ECOLOGICAL REVIEW

February 2024

Scott & Sampson Architects has instructed Coyne Environmental to carry out an Ecological Appraisal (EA) of 65 Crescent Road, Barnet, EN4 9RD, to establish the potential presence or absence of ecology on the site. This is part of a study for the submission of a planning application to Barnet Borough Council (BBC) of proposals for new housing.

Proposed Site Plan
1 : 200

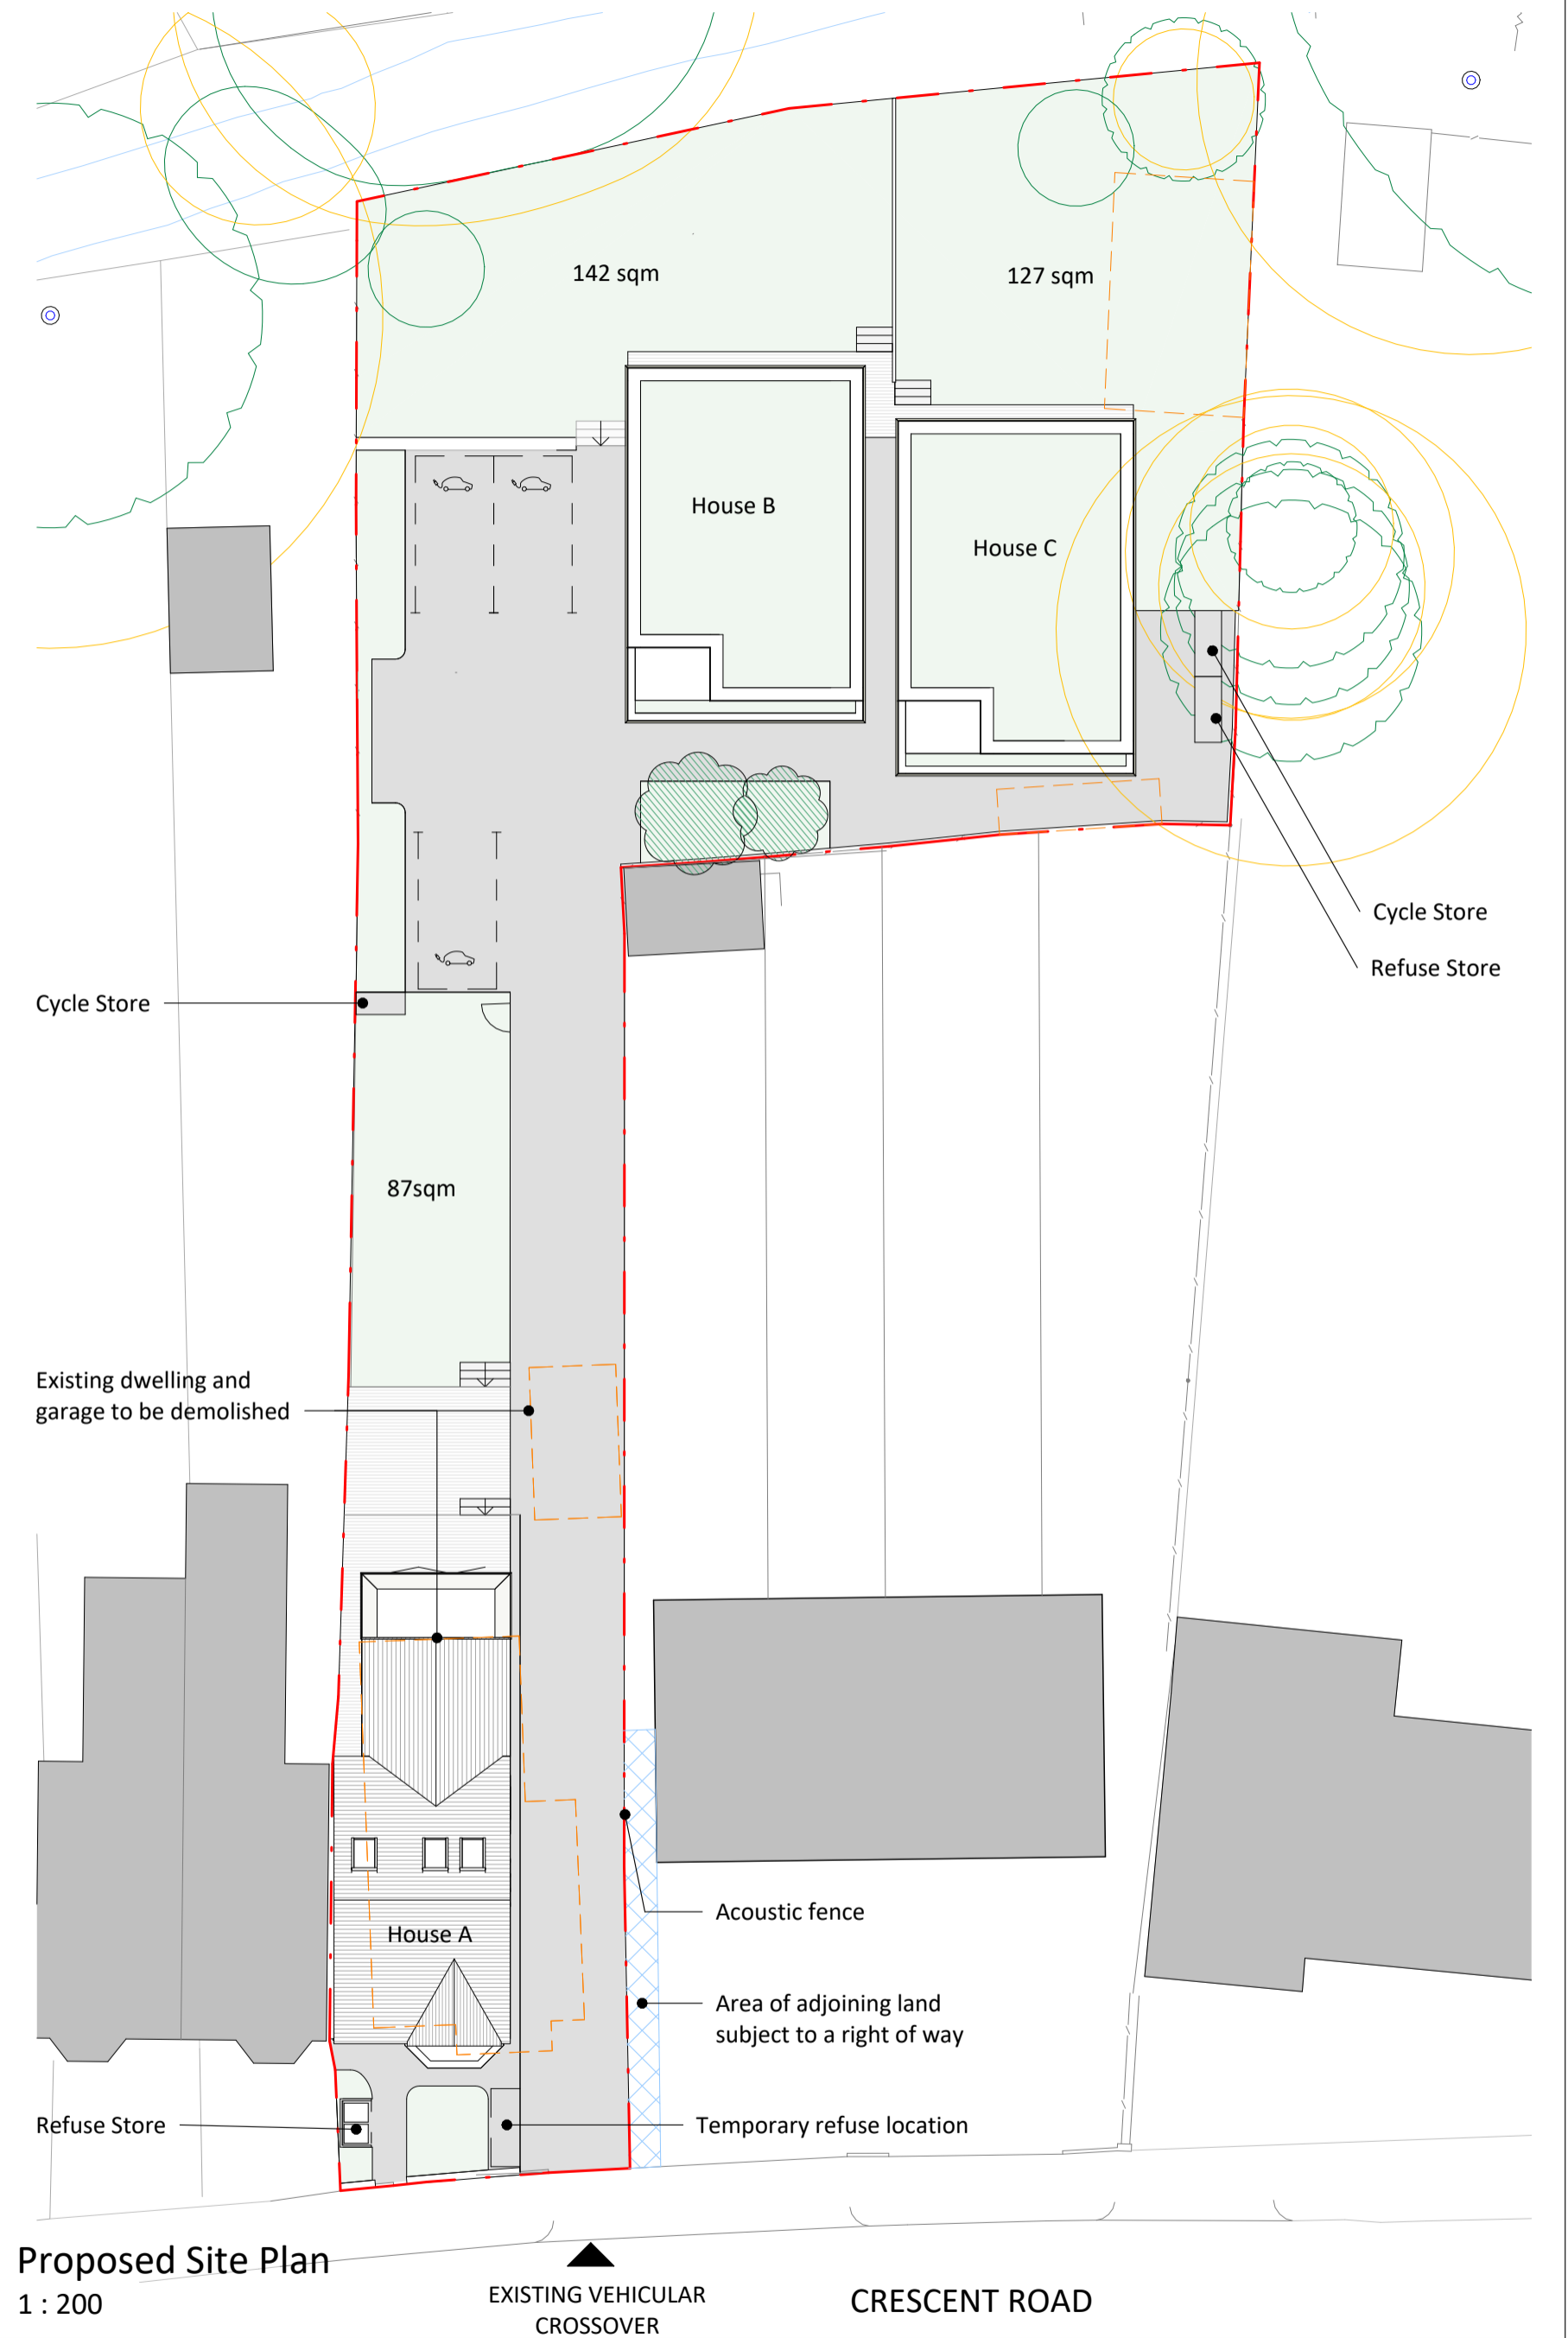
“The proposed development is advised to be scaled back and position to ensure that a sufficient buffer is given to the adjacent broadleaved woodland and Pymmes Brook at least a minimum of 8m from the bank of the brook to reduce the risk of direct damage or pollutant entering the brook and its associated habitat”.

The Council has requested that the proposed development retains a buffer zone along the Pymmes Brook boundary. It is recommended that at the detailed design stage a landscape plan is prepared with ecological planting within this area. This will provide any wildlife passing along the Pymmes Brook an additional habitat as well as a new landscape design to accompany the proposed development and increase overall biodiversity

Existing Block Plan  
1 : 500

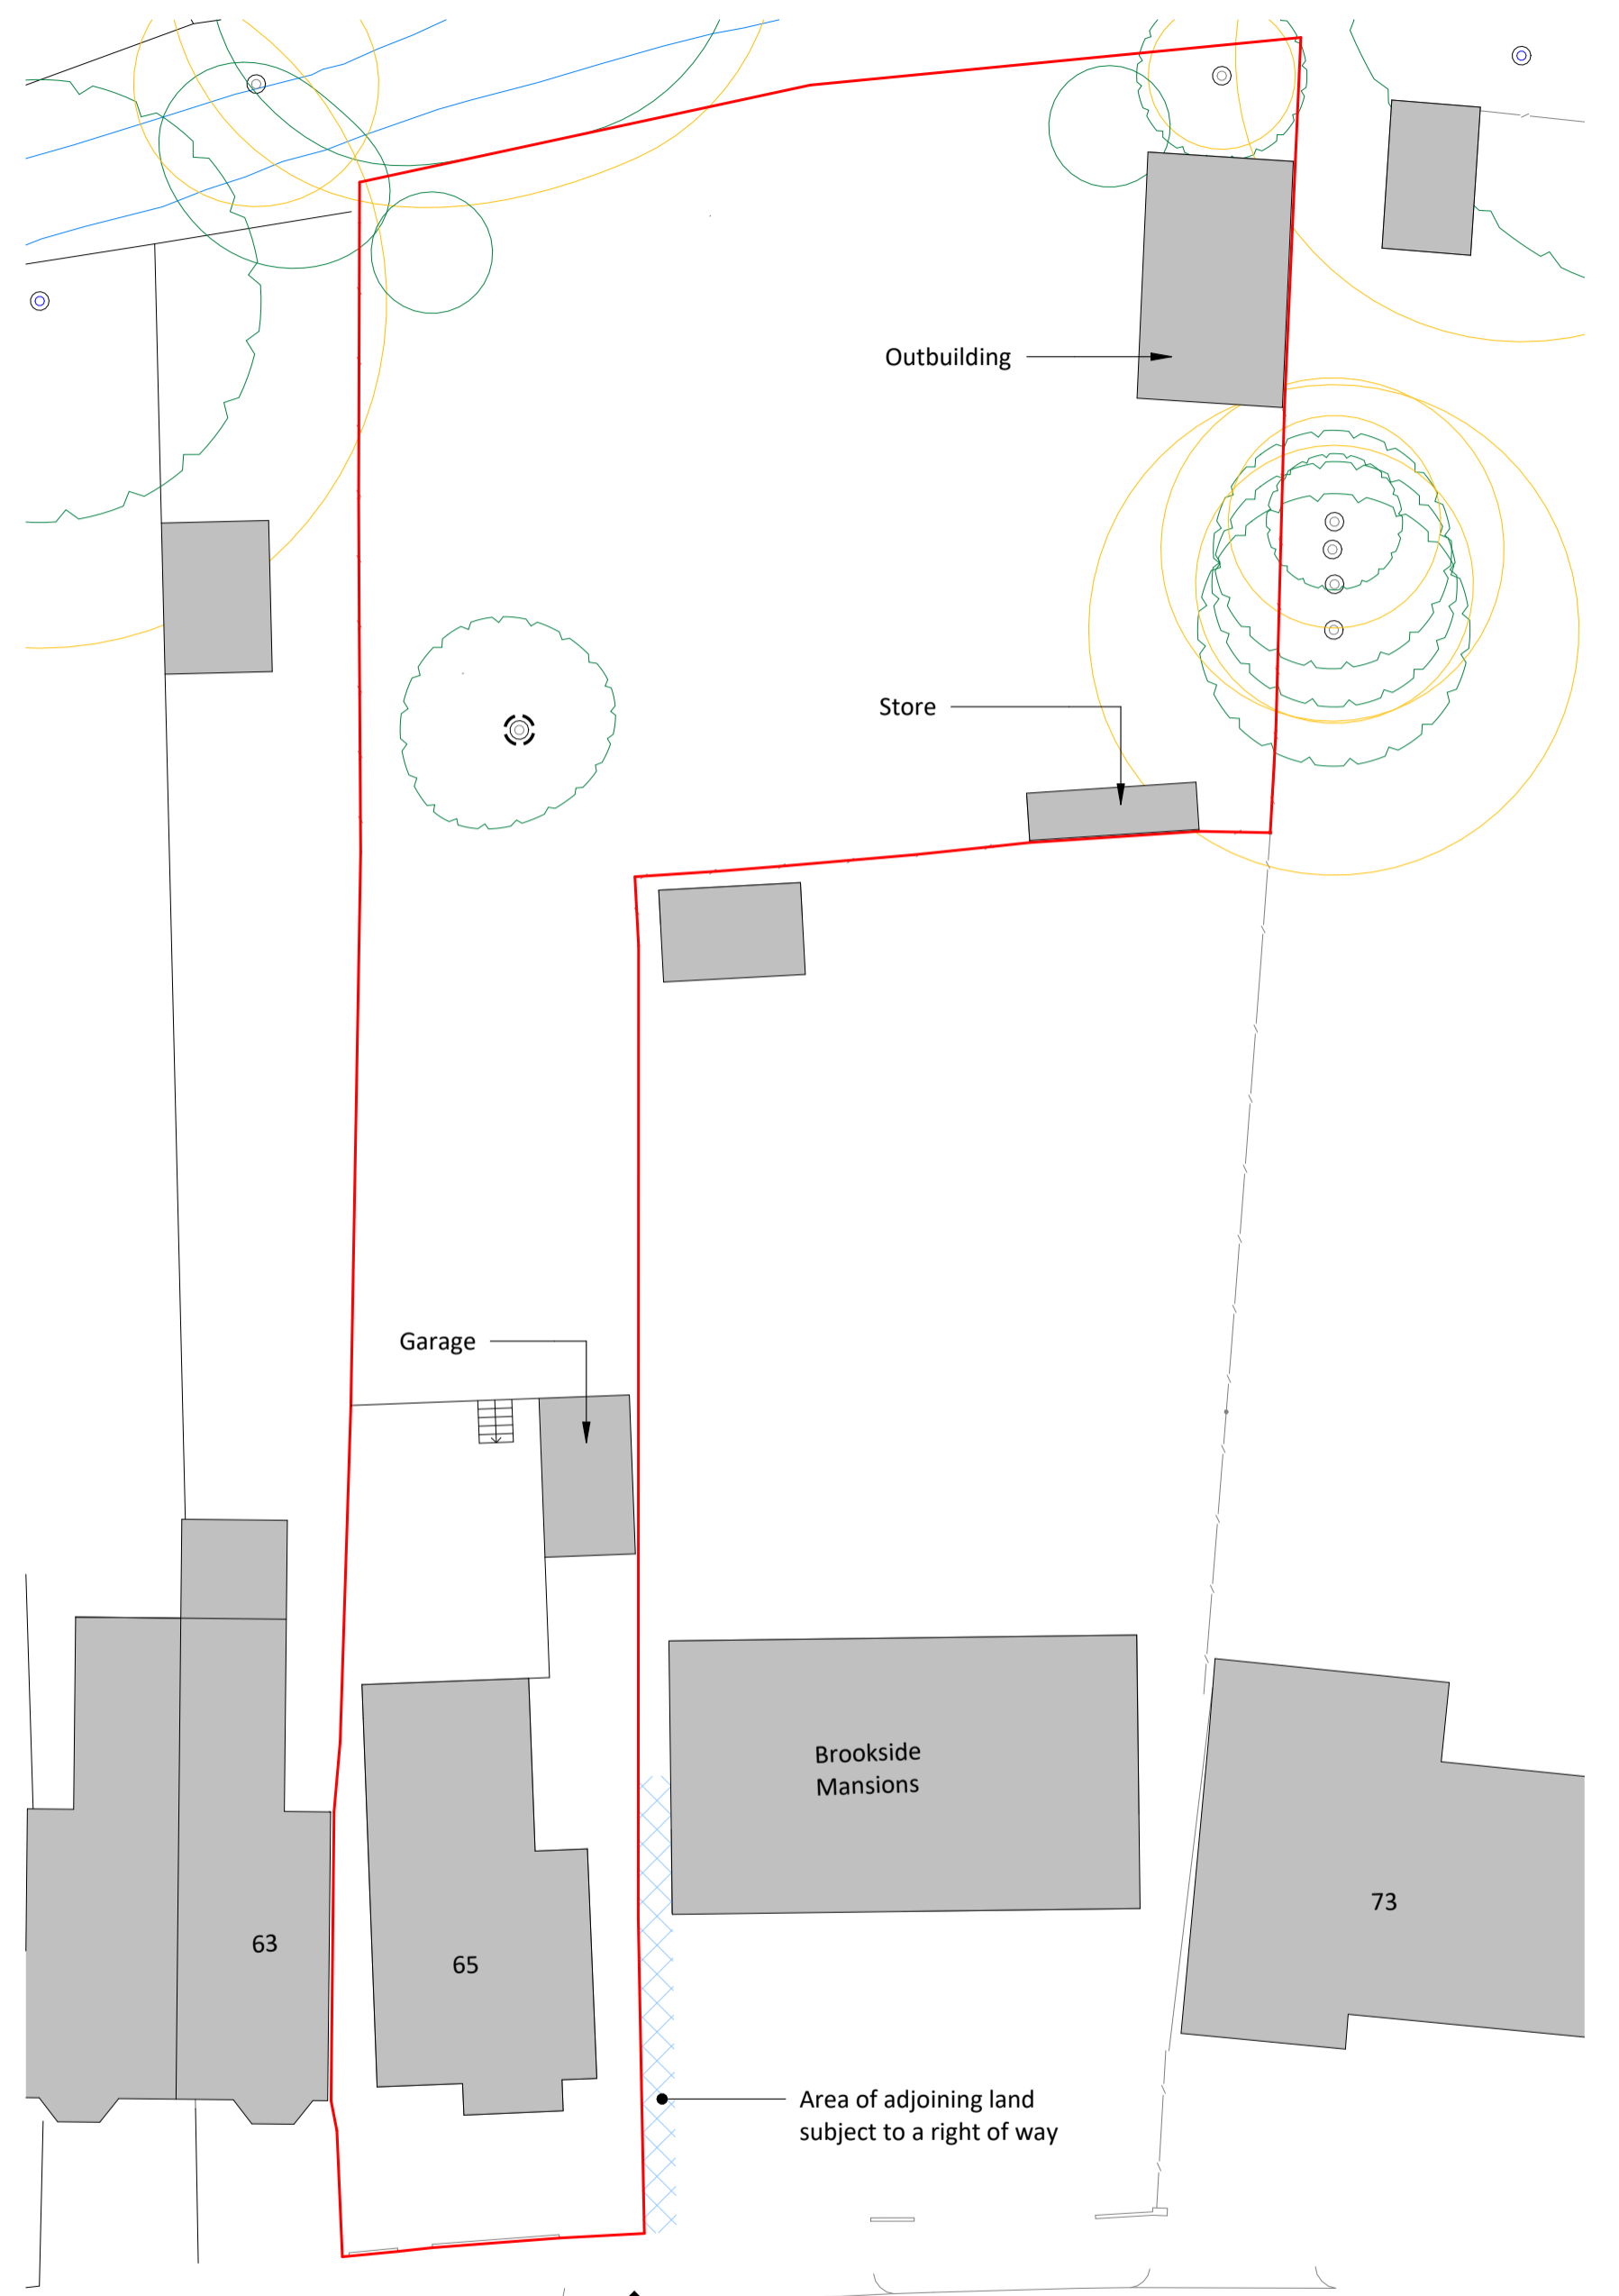
“no information was provided on the condition of the single outbuilding and shed or the presence/absence of any potential roost features to support roosting bats. The Ecological Appraisal will need to be amended to provide details on those buildings that were referenced within the Existing Site Plan (Scott & Samson Architects, 1620.P1.02, 01/12/2023) on site and their suitability to support roosting bats (as appreciate).

The two small combined sheds are almost derelict and full of discarded materials, which have de-composed for not being moved for a long time. As they are also made of asbestos, they are now a potential hazard and are due to be demolished and moved to a designated disposal site. No evidence of bats ever being present was found.

The detached garage was also inspected. This is also of asbestos construction throughout, currently used for storage and in poor condition. This type of building would not be used by bats and no evidence of them was found. This will be demolished similar to the sheds.

The detached garage and small sheds have now been inspected for bats and nothing was found. As these structures are not only in poor condition but made of asbestos, they are due to be removed to a dedicated disposal site.
